KITTITAS COUNTY

MEMORANDUM

DATE: December 6, 2012

SUBJECT: O'Keefe No 2 Short Plat SP-12-00006

O'KEEFE NO. 2 SHORT PLAT

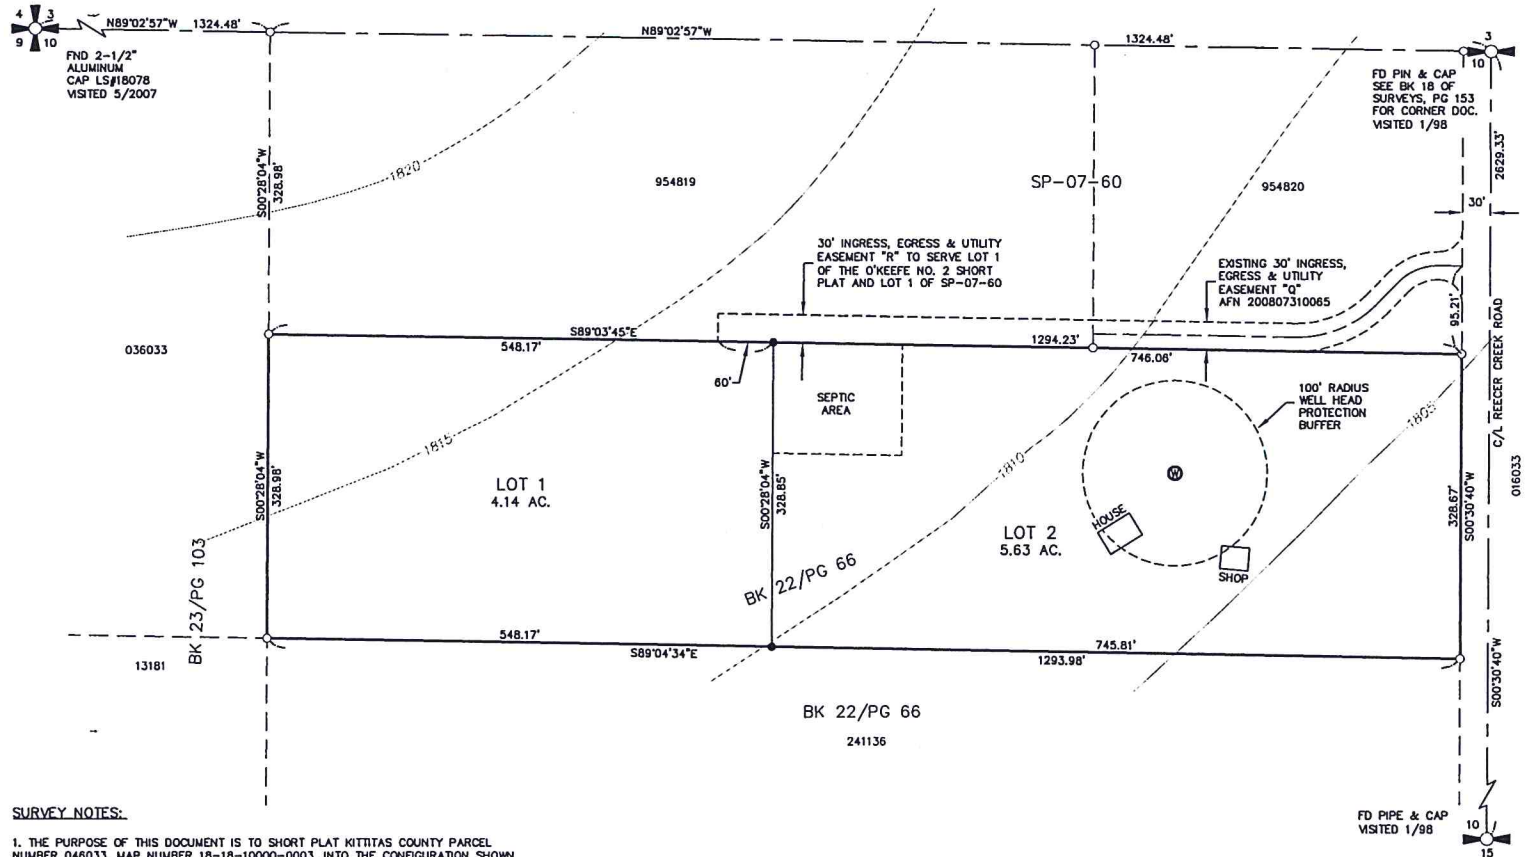
1. Lot 1 Access: Lot 1 may share a driveway with Lot 2 or may share a driveway with Lots 1 and 2 of the O'Keefe No. 1 Short Plat SP-07-60.
 - a. If Lot 1 shares a driveway with Lot 2, the conditions of No. 2, 3, 4 and 5 are not applicable.

- b. If Lot 1 shares a driveway with SP-07-60, the driveway must be constructed as a private road including paved apron, turnaround and road certification. Because a note on SP-07-60 states the access is only for Lots 1 and 2, a note shall be placed on the O'Keefe No. 2 Short Plat stating that the easement from SP-07-60 is being amended.

4. Private Road Improvements: Access shall be constructed to meet or exceed the requirements of a High-Density Private Road that serves 3-14 tax parcels. See Kittitas County Road Standards, 9/6/05 edition.

- a. Access easements shall be a minimum of 40' wide. The roadway shall have a minimum width of 20', with 1' shoulders, for a total width of 22'.
 - b. Minimum centerline radius will be 60'.

- c. Surface requirement is for a minimum gravel surface depth of 6".

- d. Maximum grade 8% flat, 12% rolling or mountainous.
 - e. Stopping site distance, reference AASHTO.
 - f. Entering site distance, reference AASHTO.
 - g. Maintenance of driveway approaches shall be the responsibility of the owner whose property they serve. The County will not maintain accesses.

- j. All easements shall provide for AASHTO radius at the intersection with a county road.
 - k. A paved apron shall be constructed at the intersection of the proposed private intersection and the county road.

5. Turnaround: A cul-de-sac turn-around having an outside right-of-way or easement diameter of at least 110 feet shall be constructed at the closed end of all dead-end roads serving 3 or more lots. The driving surface shall be at least 96 feet in diameter. Cul-de-sacs must also conform to the requirements specified by the 2009 International Fire Code. A hammerhead may be constructed in place of a cul-de-sac with approval of the Fire Marshal. Contact the Fire Marshal regarding any additional cul-de-sac requirements.
